Planning Application Ref: Y/91/17/OUT

Location: Land at Bilsham Road, Yapton

Description of works: Outline application for the development of up to 250 residential dwellings (Class C3) vehicular access, public open space, ancillary works and associated infrastructure. Departure from the Development Plan

- Key.
- RPA for CAT A\* tree to be retained
  - RPA for CAT B\* tree to be retained
  - RPA for CAT C\* tree to be retained
  - RPA for CAT U\* tree to be retained
  - Canopy of tree to be retained
  - Canopy of CAT U\* tree to be removed

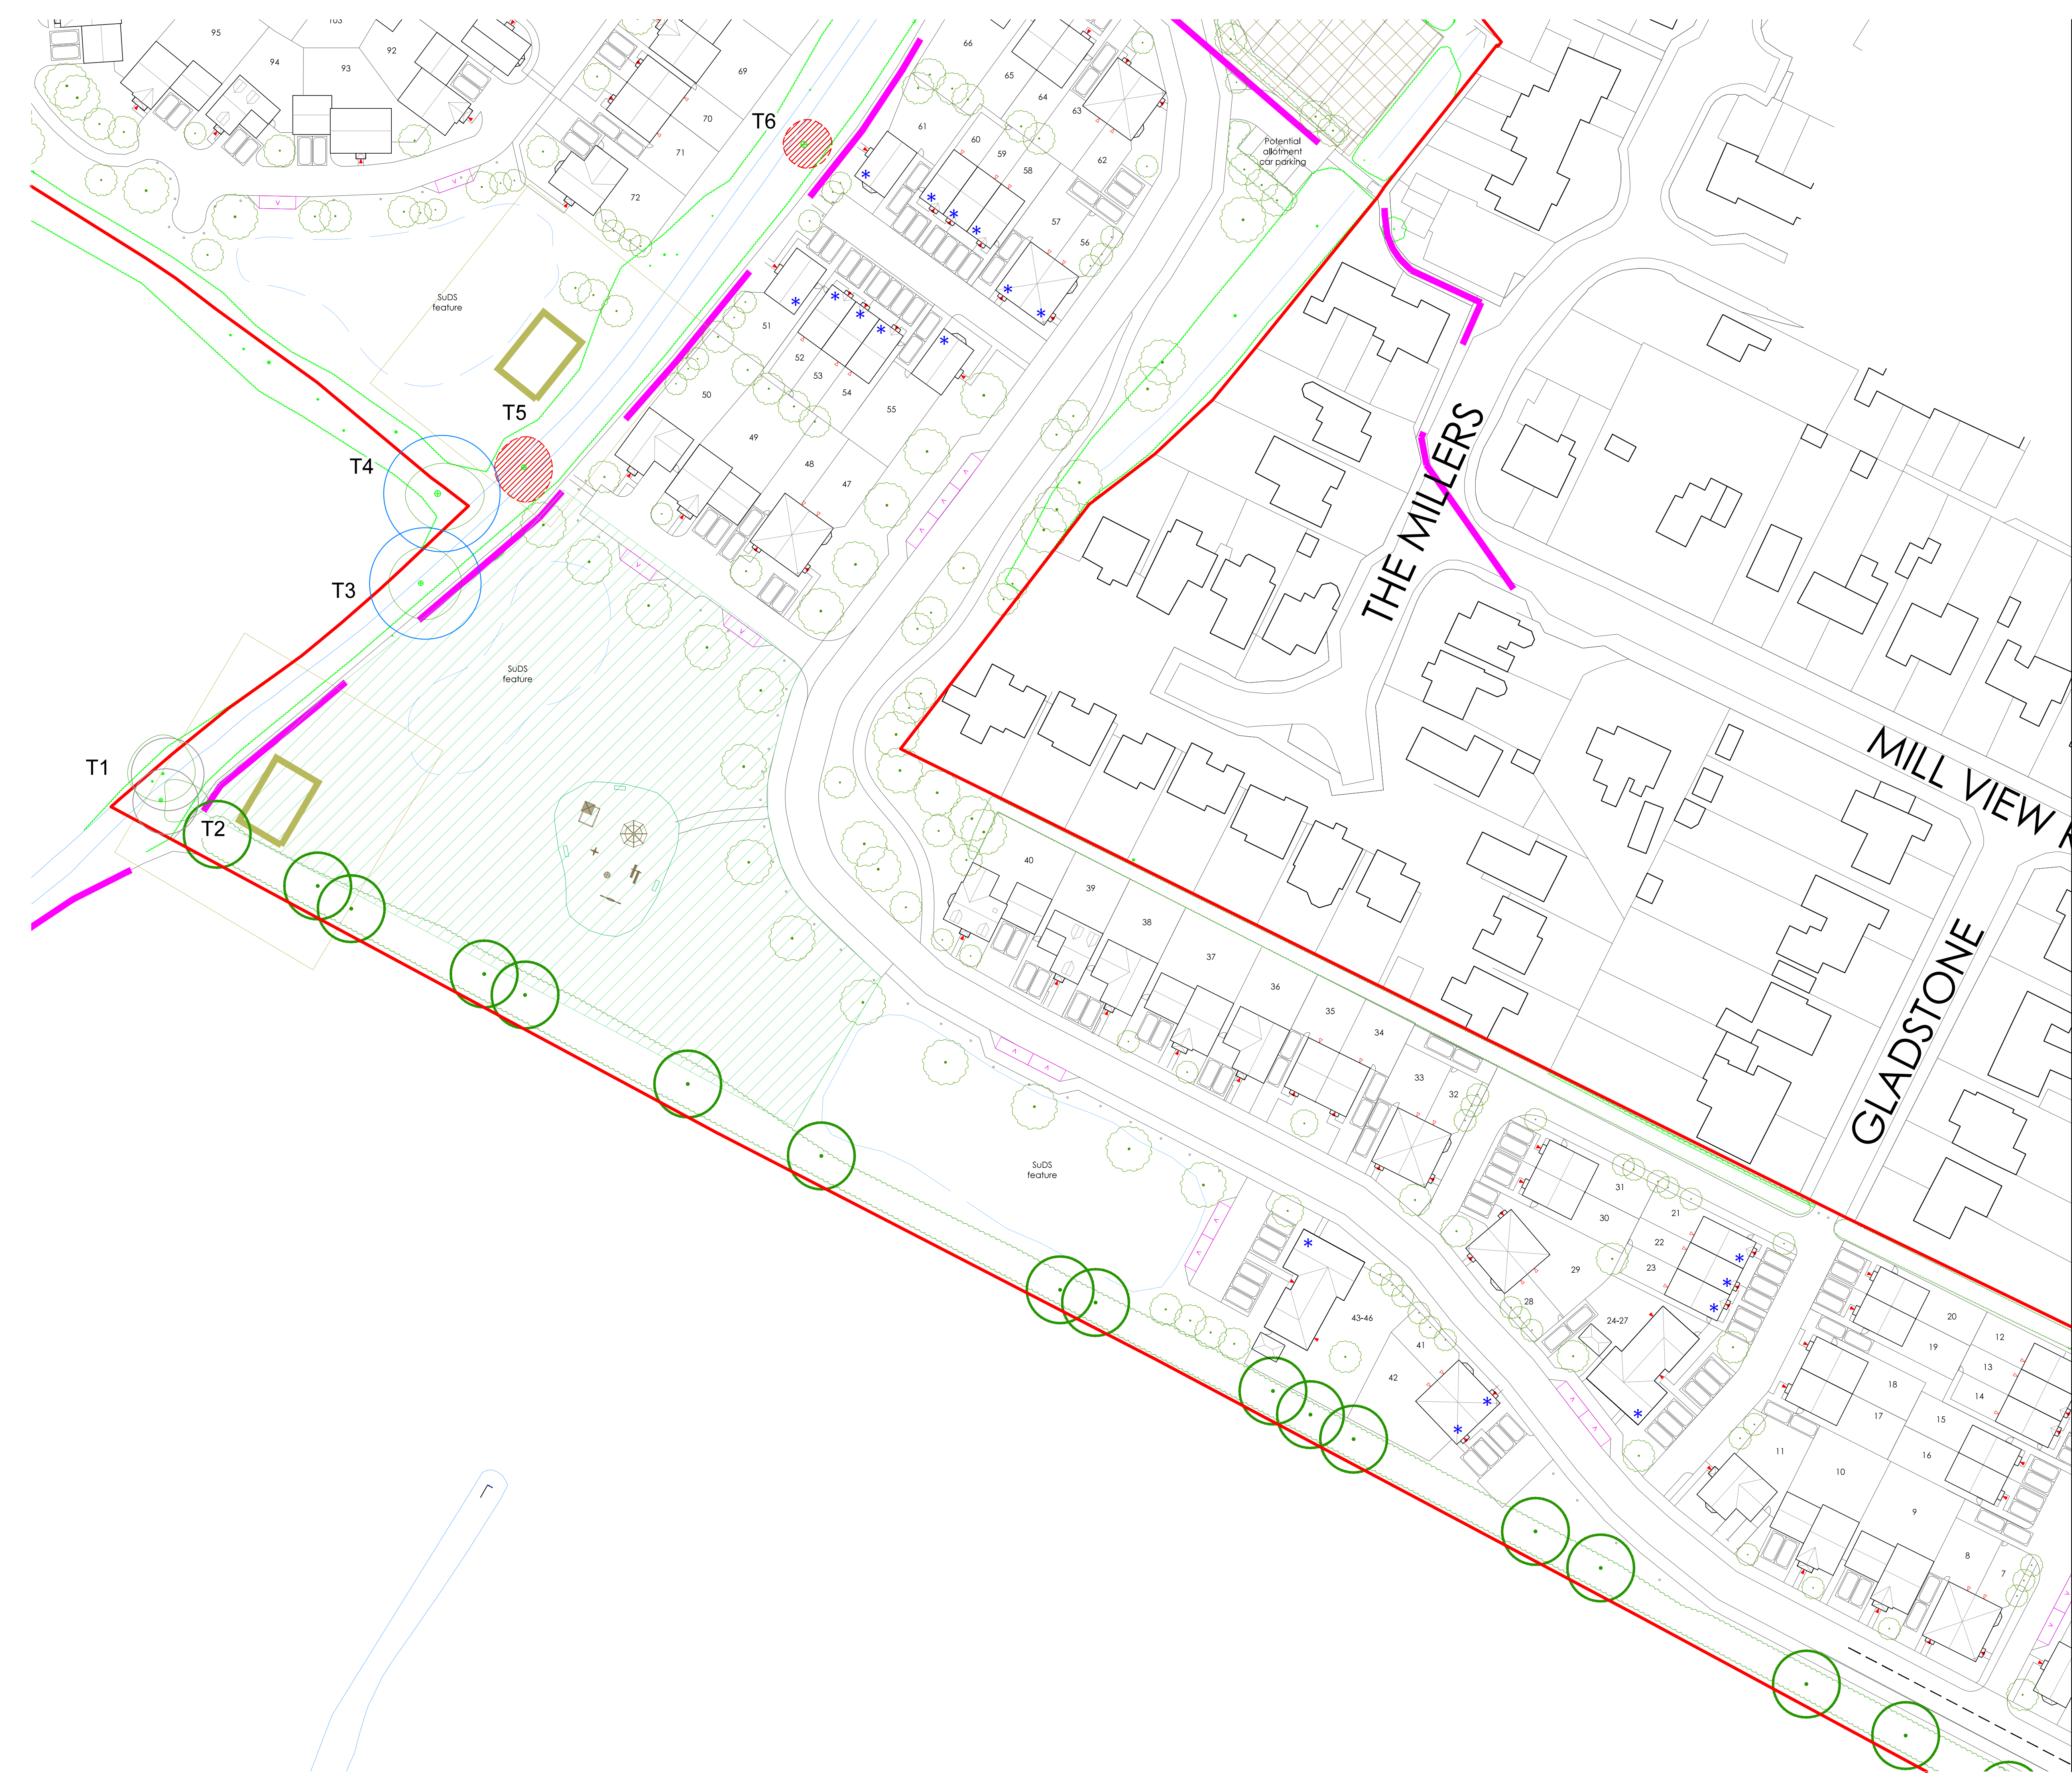
- The applicants employed the PJC Consultancy back in November 2017 to undertake a tree survey and then prepare an Arboricultural Impact Assessment (AIA) PJC/4699/17-02 R2. Tree Survey data is adequate at this stage and broadly accords with the requirements of BS5837:2012. I have referred to Illustrative detailed masterplan drg. 1244G.03 to assist with determining the accuracy of the Tree Constraints and Tree Retention Plans submitted by PJC with their AIA report. This allows me to gain a general understanding of how the plot layout and access routes relate to trees but is not specific enough for me to have full confidence they will be adequately respected and protected.

- The site contains a number of significant trees, both within and along most aspects of the site perimeter. These have already attained considerable landscape value and have potential to provide a long-term aesthetic contribution to the proposed development. **The stem diameter readings (an important factor informing the appropriate extent of RPA) are reasonably estimated but many of the tree heights are substantially underestimated and retention categories suggest an inclination to demote their status.**

- At this outline stage, the indicative layout and access arrangements and the appointed arboriculturalist's general regard for significant trees existing on site are encouraging and I am in broad agreement with their survey information. That said, I am concerned that there appear to be notable omissions in respect of existing tree cover along several sections of the site perimeter (South, adjacent arable farmland – East, rear of The Millers – North, south of dwellings at Tack Lee Road). This may be deliberate as the proposed design does not at this stage suggest any direct interference with them but it is important to consider all trees whether they are on or off-site and within potential influencing distance, so as to inform the site layout design which may of course be subject to revision. Any omissions will need to be addressed and therefore included in the aforementioned TPP and AMS should this proceed to a full planning application. **Despite appearing in symbolic form on the Illustrative detailed masterplan drg. 1244G.03, significant trees located within the Southern site perimeter hedgerow were omitted from the tree survey schedule provided by PJC. They are of such dimensions and proximity as to be a material consideration and will require inclusion in any subsequent TPP and appropriate levels of protection before any work can commence on site. I have determined that the majority of these merit a TPO.**

ecological value. For it to be retained satisfactorily within the development, the proposal to 'cap' the RPA at 15m radius should be re-visited to prevent any disturbance to the root system and provide this tree with the room to endure without coming under pressure for hazard abatement pruning work. Such work would reduce its ecological and habitat value greatly. The current proposal to install a footway within the North sector of the RPA (despite the suggestion of 'no-dig' construction methodology) and position a private garden beneath the crown spread on the South aspect are clearly incompatible with these objectives.

- I am pleased to see there is intent to retain the vast majority of recorded trees in harmony with the development, but I cannot be satisfied that this will be achievable until we receive a Tree Protection Plan (TPP) overlaying the final proposed site design layout, with supporting Arboricultural Method Statement (AMS) where RPA (Root protection area) incursion is anticipated - which I would expect to see submitted with a subsequent full planning application.
